Manly Council

Re: Proposed Development at d'Albora Marina, western side of Spit Road, the Spit Mosman.

I refer to your letter dated 8 March 2011. Manly Council raises the following concerns with regard to the proposed development:

address **The Spit, Mosman**
title **Floor Plan L2**

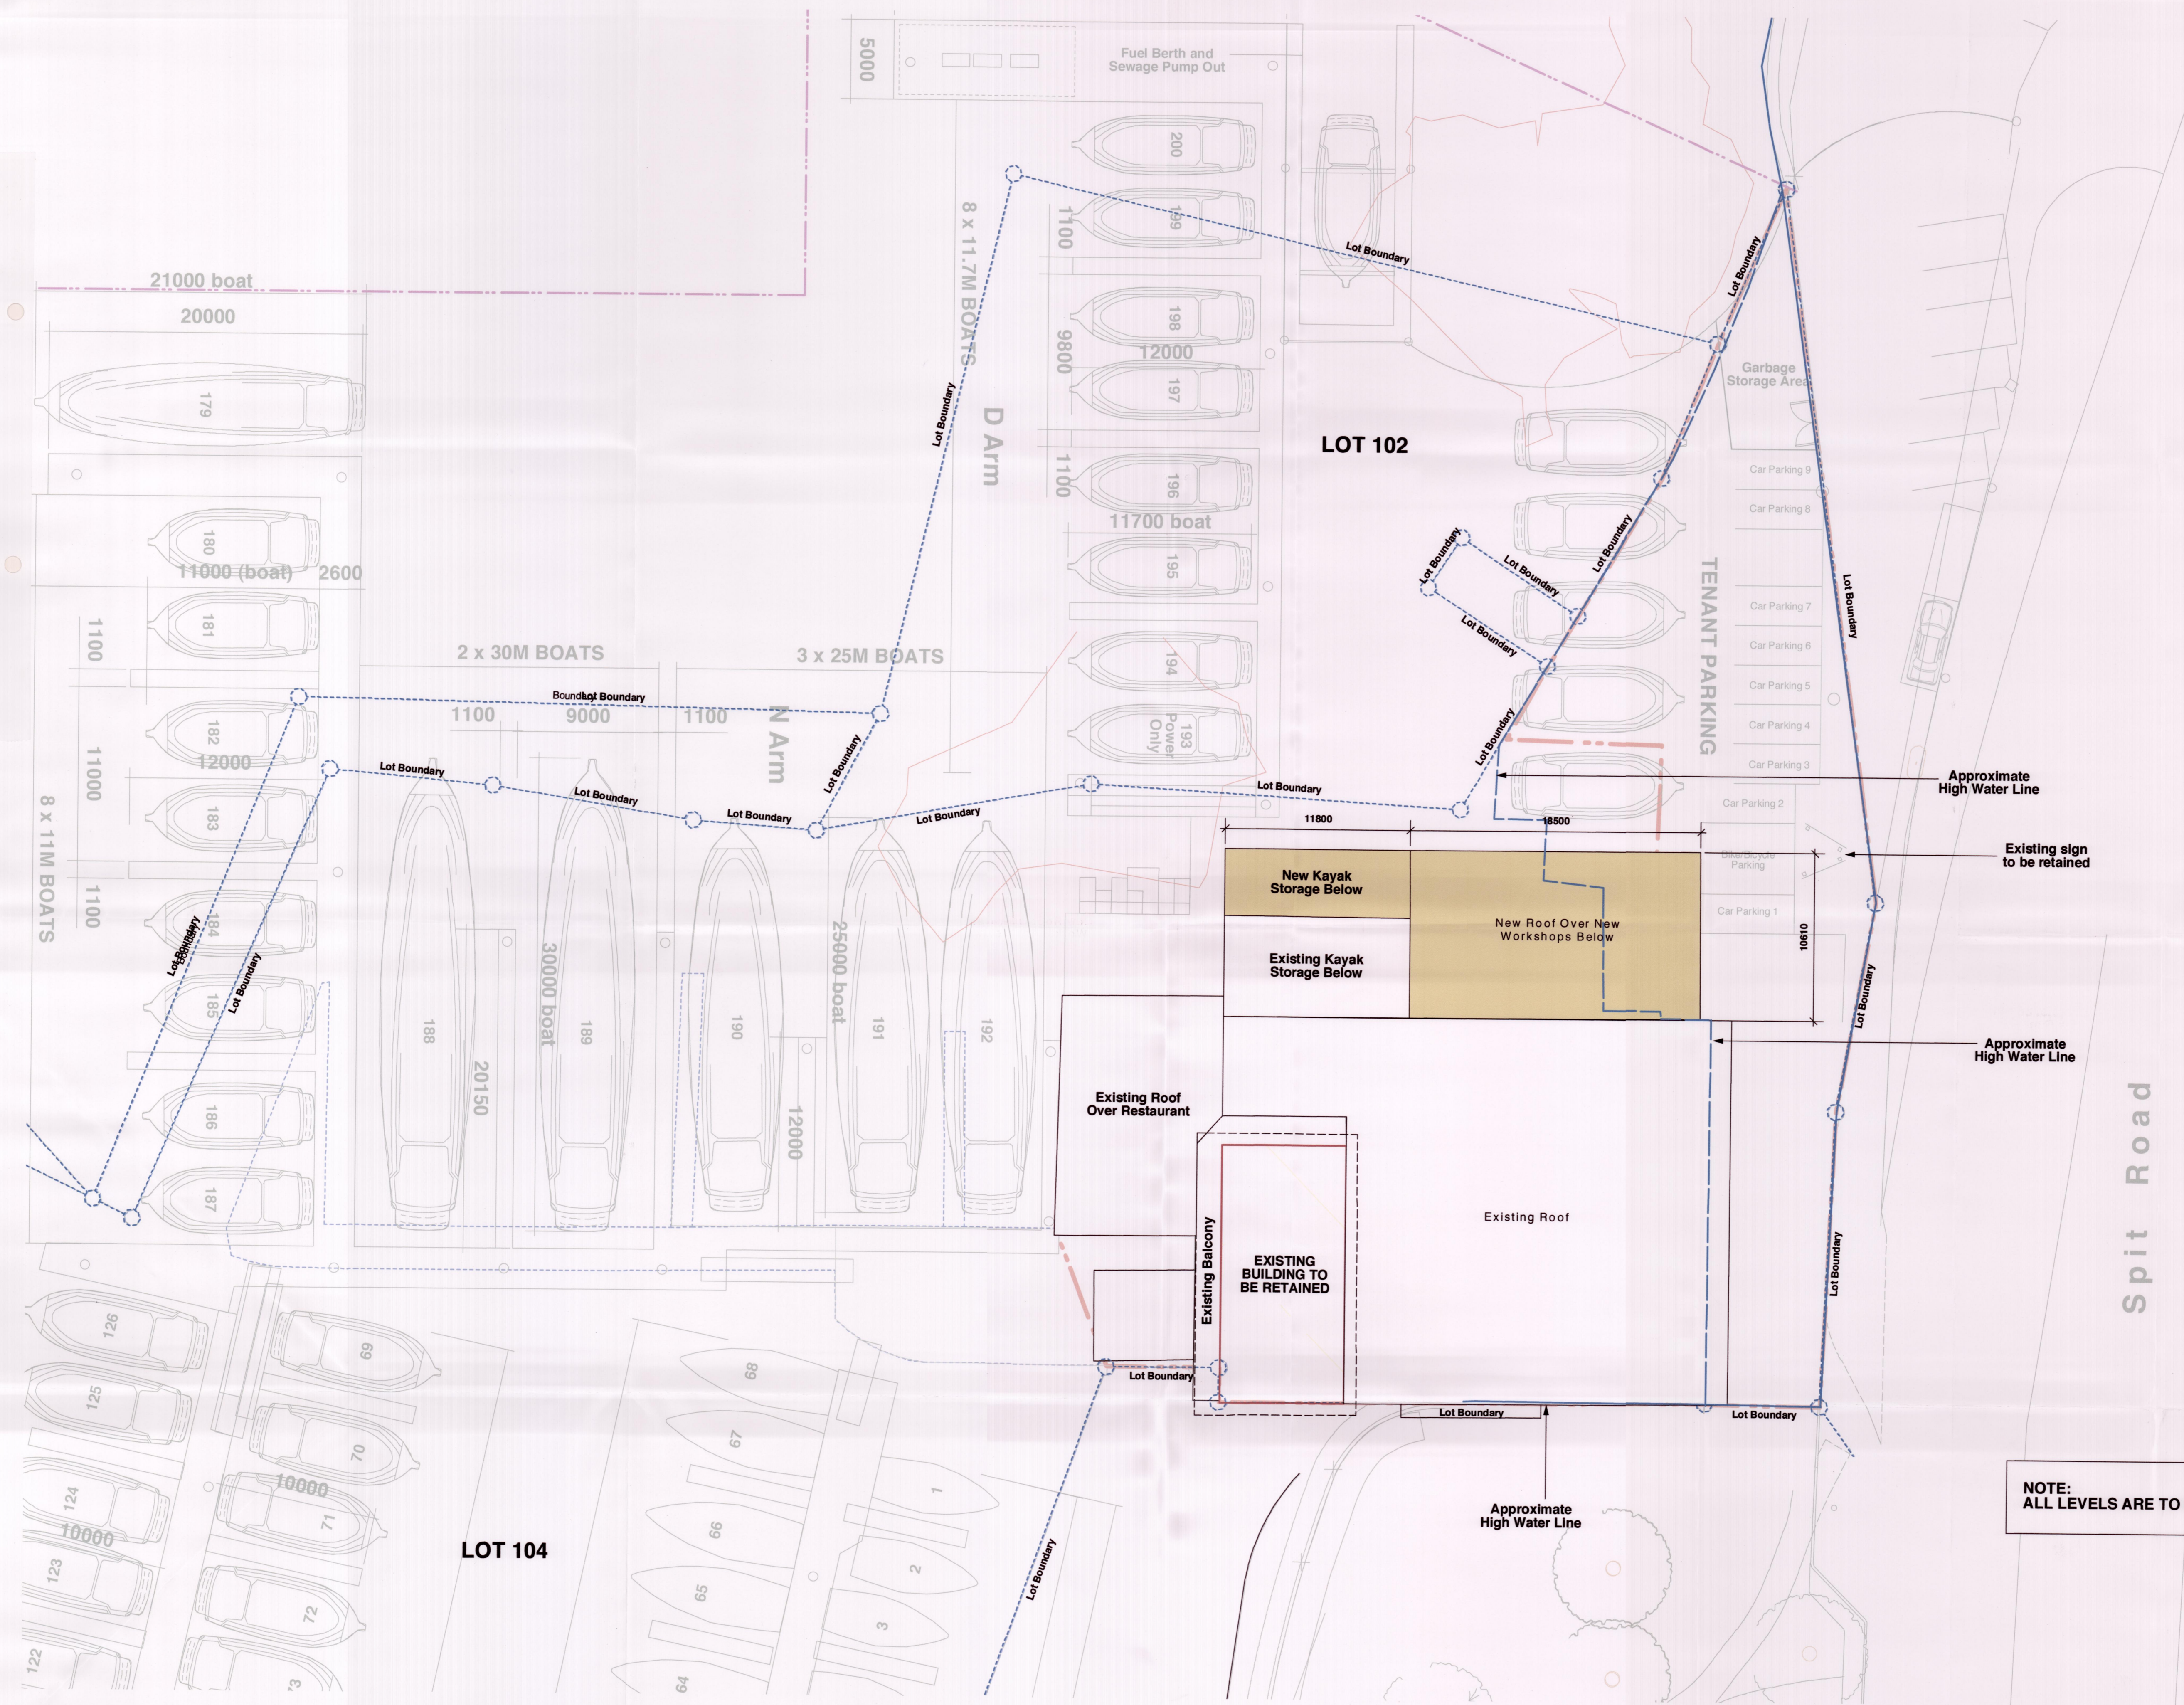
The impacts of the doubling of the size of the restaurant, its relocation to the first floor and reorientation to face the residential properties located at Seaforth is also of concern to the council in terms of the noise impacts. It is noted that the attached acoustic report leaves questions unanswered and does not appear to adequately address the potential impacts on Manly residents associated with the restaurant. In particular the acoustic report fails to address the impact of the noise issuing from the internal areas of the restaurant (given that the glazing appears to be by-fold doors), in conjunction with the two external decked areas. It is also noted that the number of patrons is given as 30 within the report and 56 seats on the plans. Clarification of the total number of patrons should be provided at the earliest opportunity.

client: Ardent Leisure Pty Ltd
address: The Spit, Mosman
project: d'Albora Marina Refurbishment
scale: 1:200
drawing no: **DA05**
issue: **G**

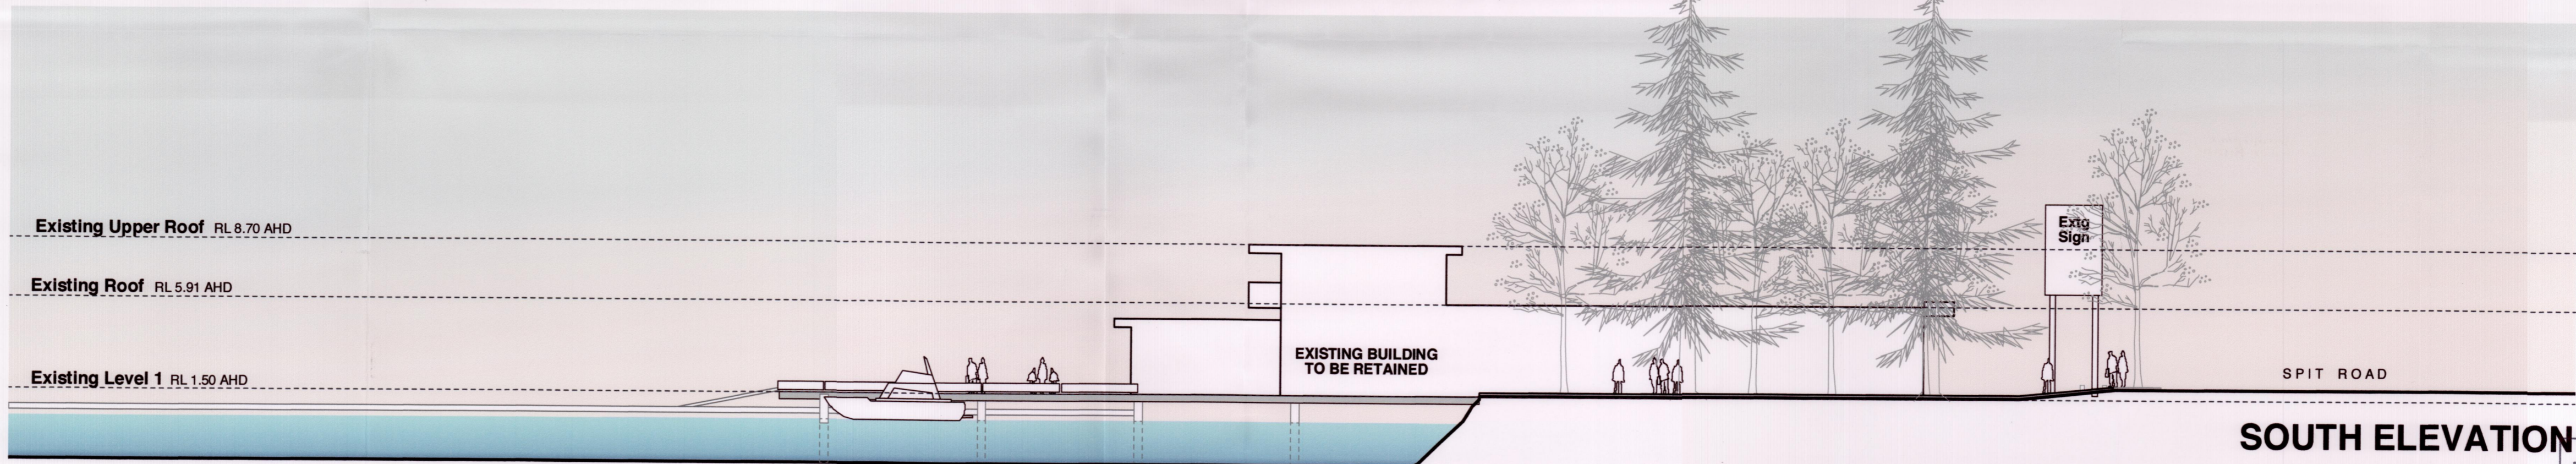
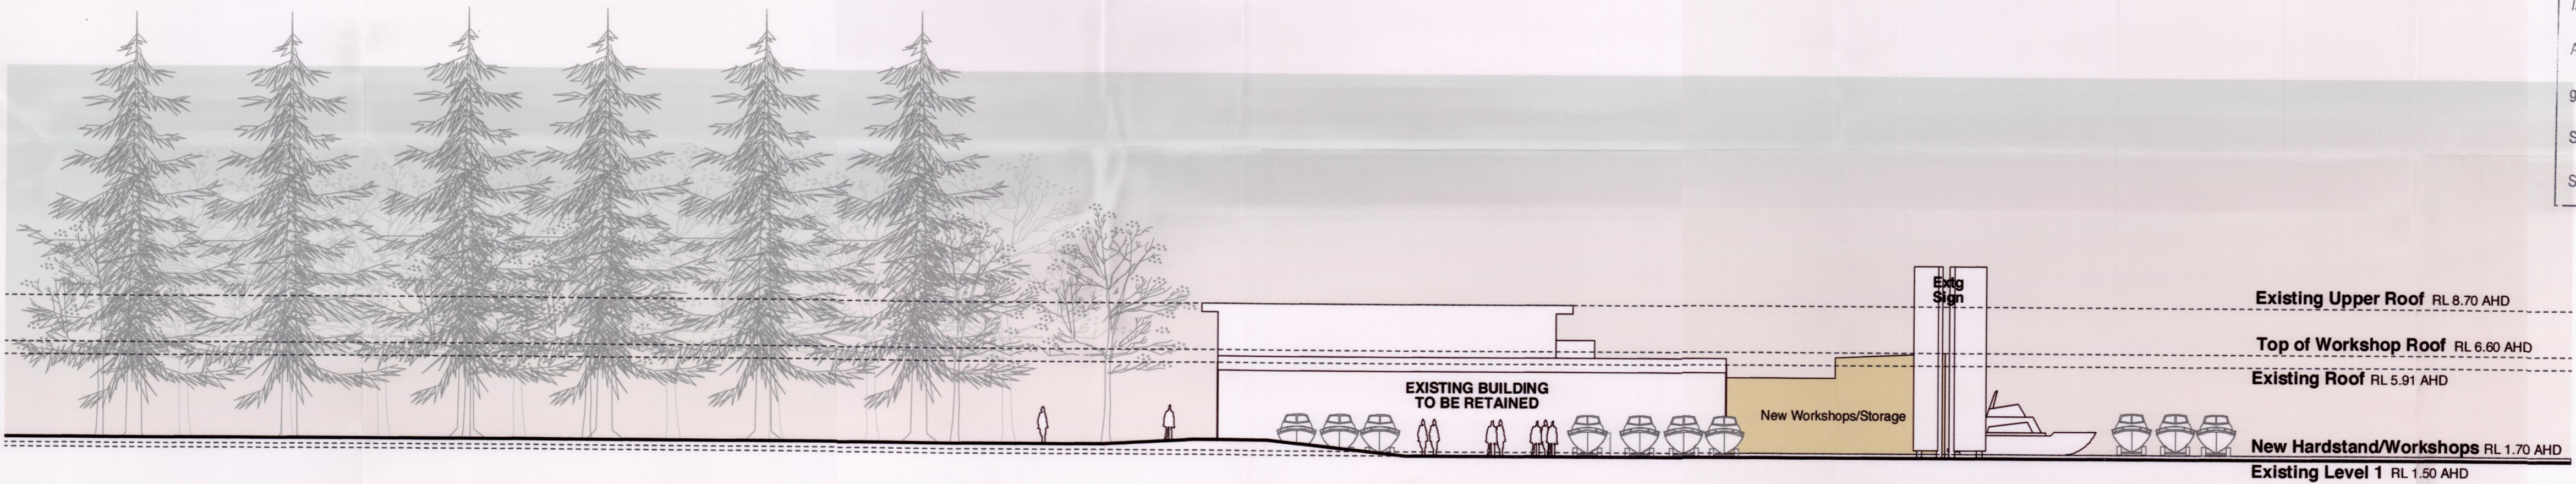
The Spit is a significant landmark in Middle Harbour. The increase in the size and scale of the buildings comprising the marina, the provision of office space and the expanded restaurant, extension of second storey will have a negative impact on views to and from the foreshore. Manly Council considers that the proposed development is an unacceptable over-development of the site given the prominent location on the north-western extremity of The Spit which is a significant natural feature projecting into the waters of Middle Harbour. Every effort should be made to minimize the impact of any urban development on The Spit and to retain the remaining natural features of a sand spit.
